**Re: Lexus of Albuquerque at 8421 Pan American Freeway
Erosion and Sediment Control Plan
Engineer's Stamp Date 2/21/2023 (F17E078)**

Based upon the information provided in your submittal received 2/22/2023, the above referenced ESC Plan cannot be approved until the following comments are addressed:

SHEET DESCRIPTION:
EROSION CONTROL PLAN

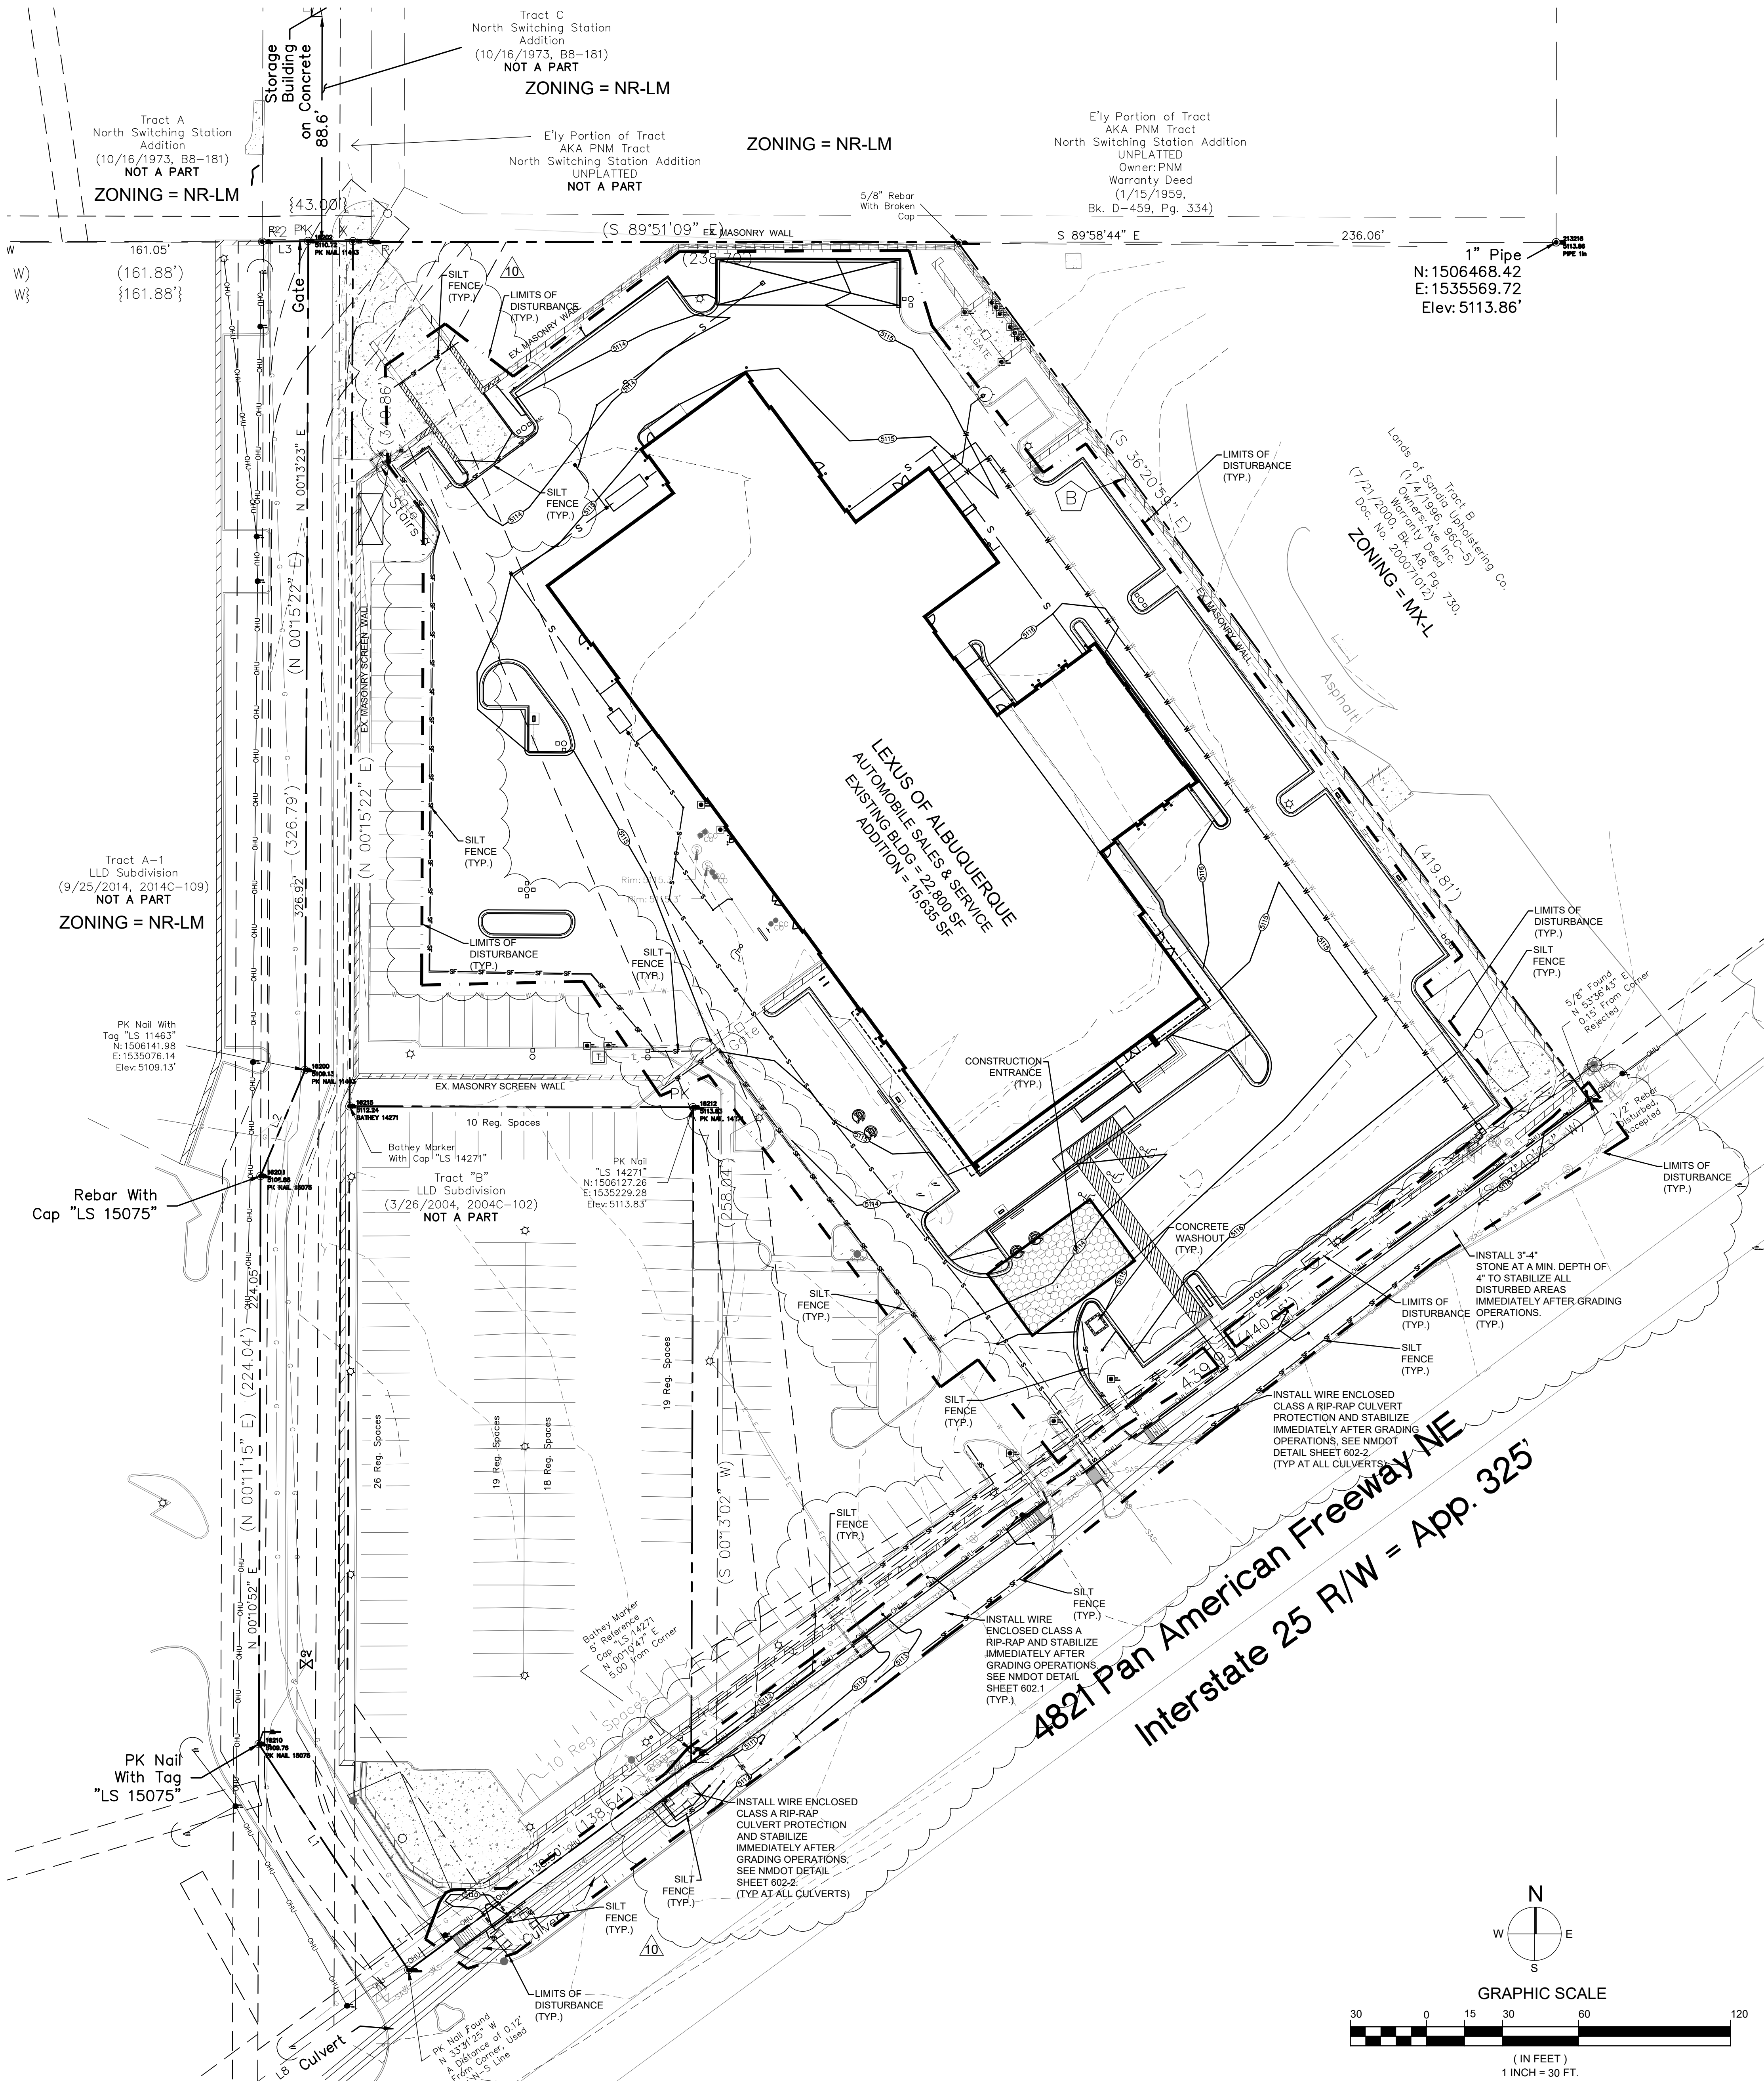
2. Identify locations of concentrated flow paths that enter and exit the disturbed areas. Identify locations where sheet flow enters and exits the disturbed area. Show on-site drainage patterns of stormwater before and after major grading activities. (CGP 7.2.4.f)

3. This site is within 100 yards of the North Diversion channel which discharges to the Rio Grande. BMPs on site need to adhere more closely to the EPA's required controls in CGP 2.2 and the attached design guide for Silt Fences. Silt fence isn't appropriate for concentrated flows.

4. Best Management Practices note #3 public notice must be revised to accurately state the posting requirements of CGP 1.5. "You must post a sign or other notice of your permit coverage at a safe, publicly accessible location in close proximity to the construction site. The notice must be located so it is visible from the public road that is nearest to the active part of the construction site, and it must use a font large enough to be readily viewed from a public right-of-way."

5. Best Management Practices note #4, please add that the SWPPP must be kept up-to-date per CGP 7.1
6. Best Management Practices note #14 conflicts with Erosion Control Note #10 regarding the frequency of inspections (14 days is acceptable) and both are wrong regarding the depth of rain that triggers the need for additional inspection (0.5" should be 0.25").

7. The SWPPP must include site-specific interim and permanent stabilization per CGP 9.4.1.c.i. The Landscape Plan can be used to satisfy this requirement and should be submitted separate from the ESC Plan with the application to the Stormwater Quality Section of the Planning Department and it should be included in the SWPPP. Provide a specification on the ESC Plan for any disturbed areas not covered by the Landscape Plan.

8. Erosion Control Note #6 should say “Where sediment has been tracked-out from your site onto paved roads and sidewalks remove the deposited sediment by the end of the same business day” CGP 2.2.4.d.

9. Erosion Control Note #10, talking about washout, should be deleted. “Direct wash water from concrete, paint, and stucco into a leak-proof container” per CGP 2.3.4. Identify the locations of the concrete washout.
